# CITY OF PORTLAND BUILDING PERMIT

This is to certify that 477 TIME & TEMPERATURE LLC –  
MAKE A WISH

Job ID: 2011-11-2691-ALTCOMM

has permission to Widen stair to add a chair lift, add closets & doors in open work area  
provided that the person or persons, firm or corporation accepting this permit shall comply with all of the provisions of  
the Statues of Maine and of the Ordinances of the City of Portland regulating the construction, maintenance and use of  
the buildings and structures, and of the application on file in the department.

# Summit® Stair Lift

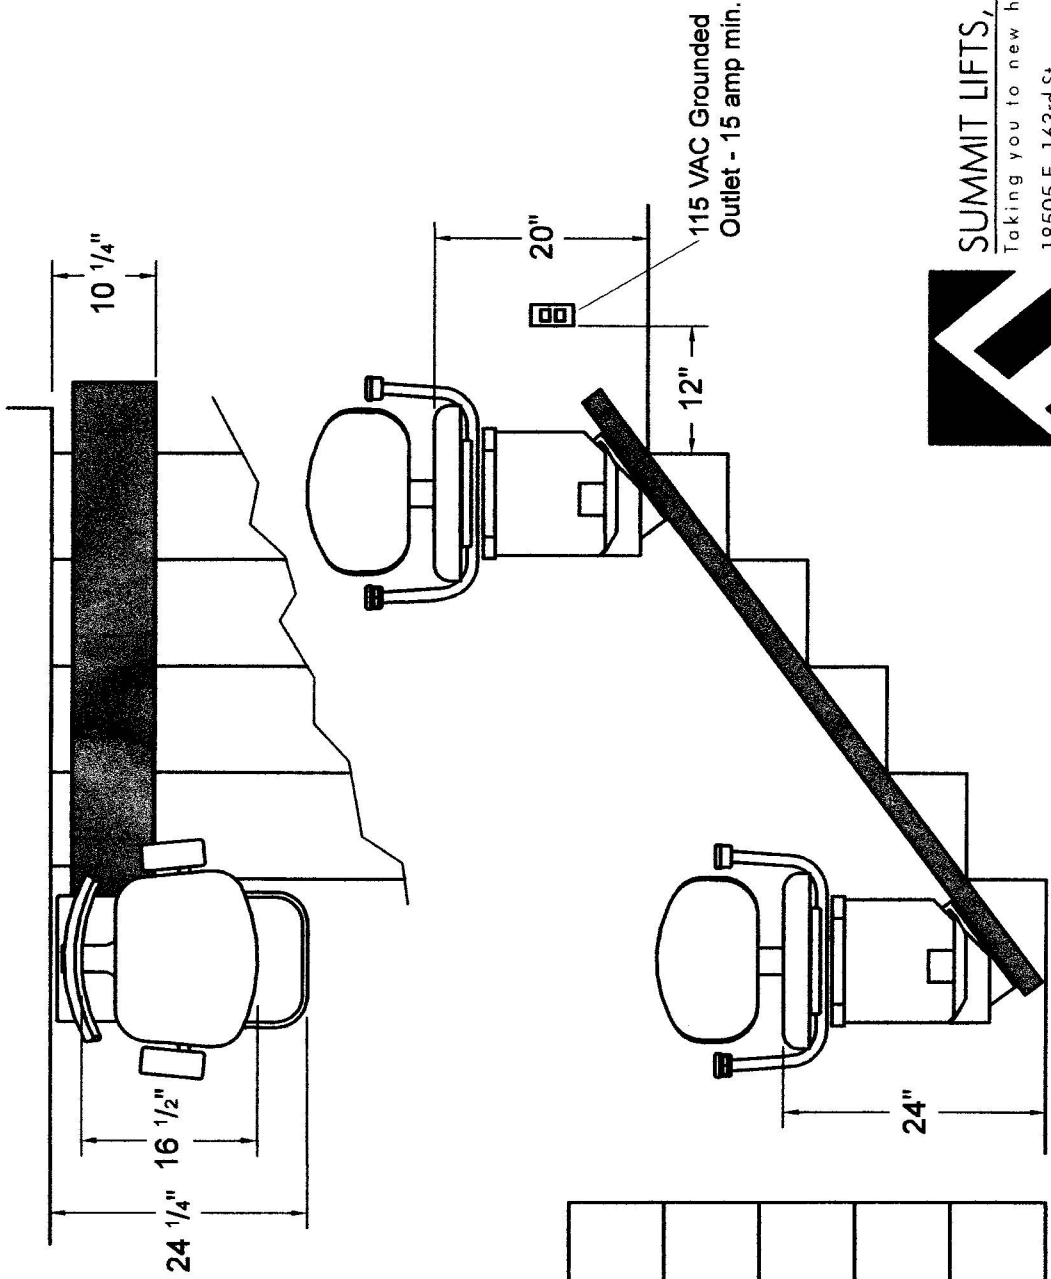
1. Application approval based upon information provided by applicant; including notes on plans per Mike D. for noncombustible framing, excepting the one additional stair stringer. Any deviation from approved plans requires separate review and approval prior to work.
2. Separate permits are required for any electrical, plumbing, sprinkler, fire alarm, HVAC systems, heating appliances, including pellet/wood stoves, commercial hood exhaust systems and fuel tanks. Separate plans may need to be submitted for approval as a part of this process.
3. Upon investigation, if any structural work is required, details shall be submitted for review and approval prior to commencement of this work.
4. The proposed stair lift shall not reduce the stair width to less than 36" when not in use.
